Application for a Non-Material Amendment Following a Grant of Planning Permission

Re-cladding works to existing buildin (Fire Risk Assessment Compliance)

21/01647/PFUL3

Omit coloured glass spandrel panels in various locations and replace with metal cladding (to match the new cladding system) installed across the development

Proposed Elevation 1  
1:100 @ A1

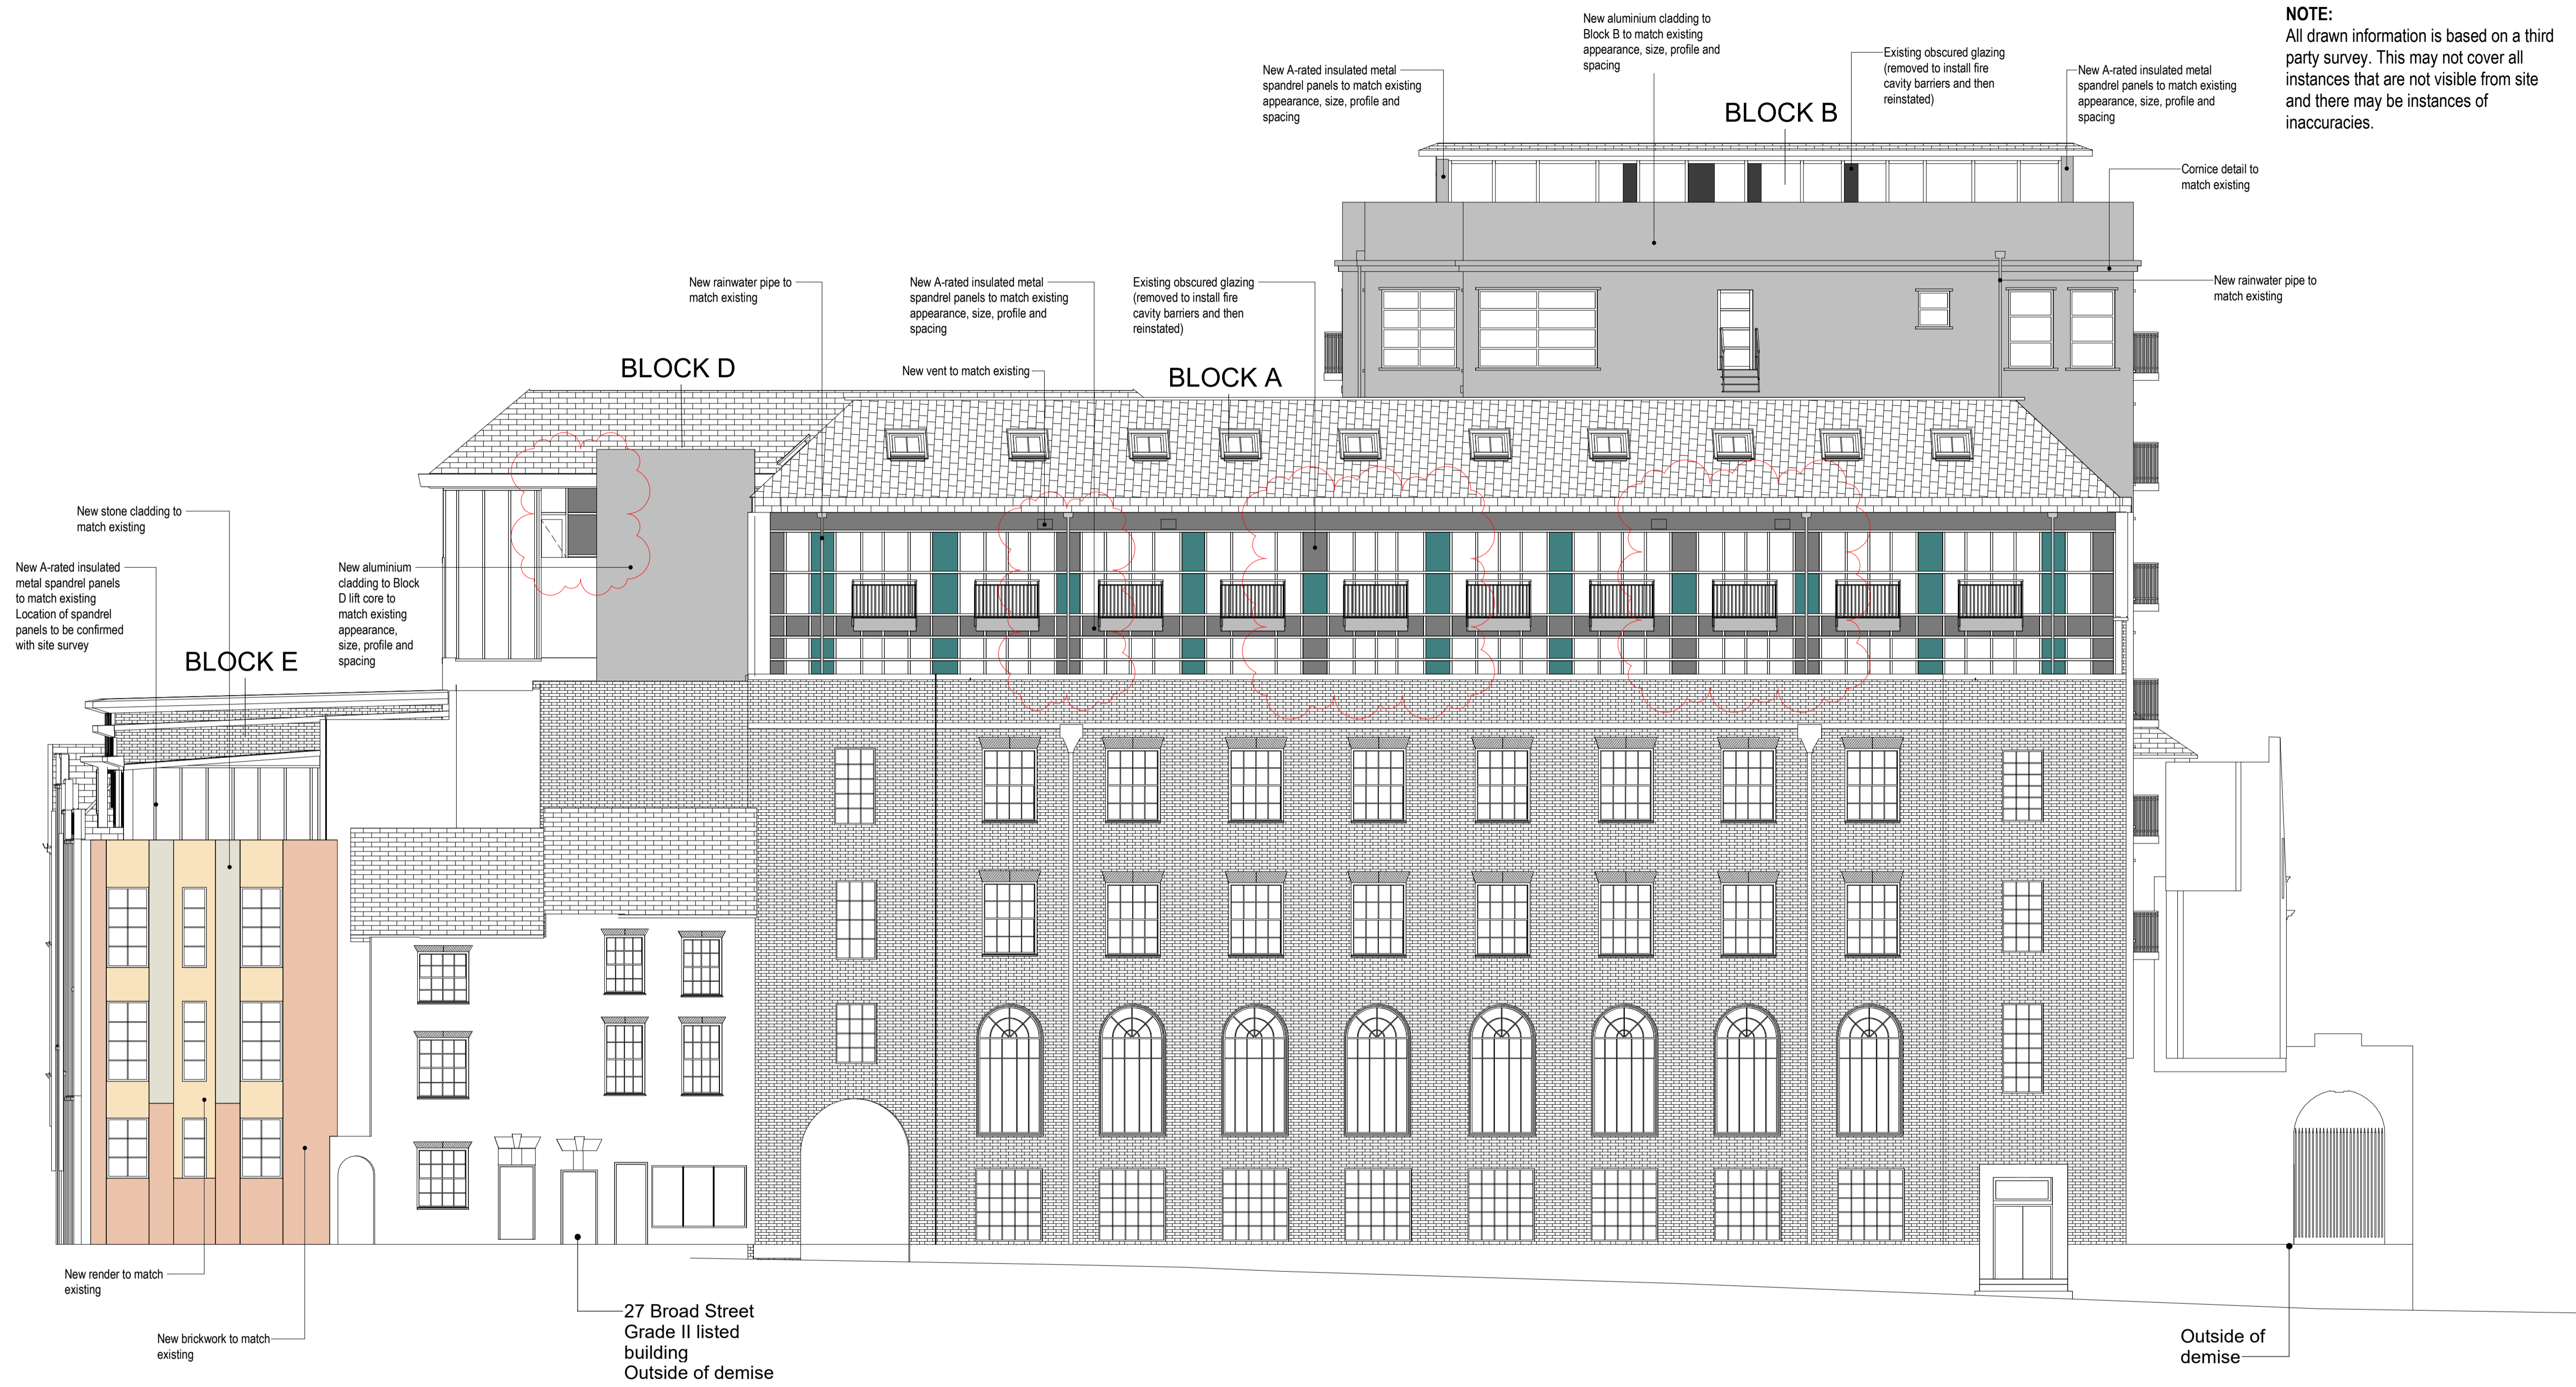
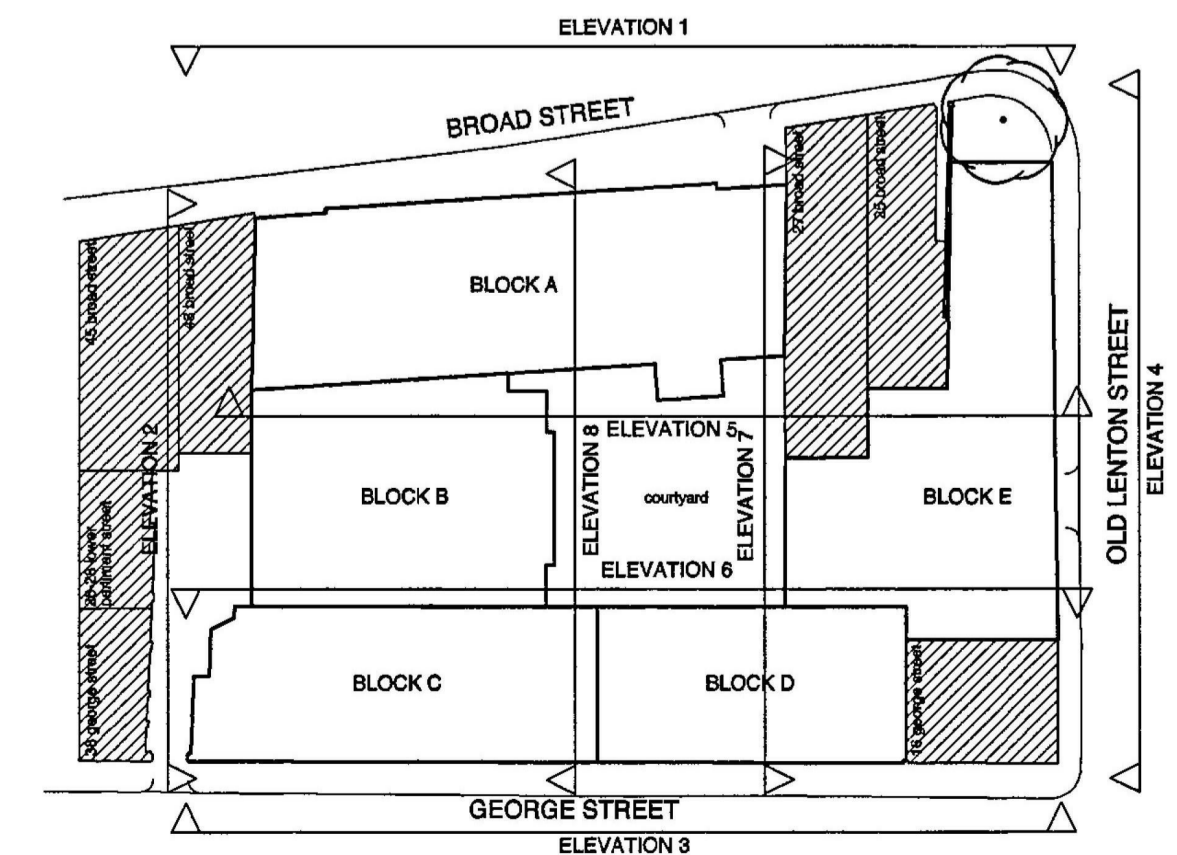
In several locations combustible insulation is positioned behind coloured glass spandrel panels within the glazing system to Blocks A, C and D and requires removal. The combustible insulation is bonded to the glass resulting in damage to glass during removal, and the coloured glass is achieved by combustible interlayers in the bonded glass system. The replacement glass specification to replace the existing (when removed) does not meet the performance, technical requirement of fire performance of the system and will require replacement with a metal cladding cladding panel (to match the new cladding installed as part of the development).

5413-HMA-CE-ZZ-DR-A-00212_P3 - Proposed Elevation 1
5413-HMA-CE-ZZ-DR-A-00213_P3 - Proposed Elevation 2
5413-HMA-CE-ZZ-DR-A-00214_P3 - Proposed Elevation 3
5413-HMA-CE-ZZ-DR-A-00215_P3 - Proposed Elevation 4
5413-HMA-CE-ZZ-DR-A-00216_P3 - Proposed Elevation 5
5413-HMA-CE-ZZ-DR-A-00217_P3 - Proposed Elevation 6
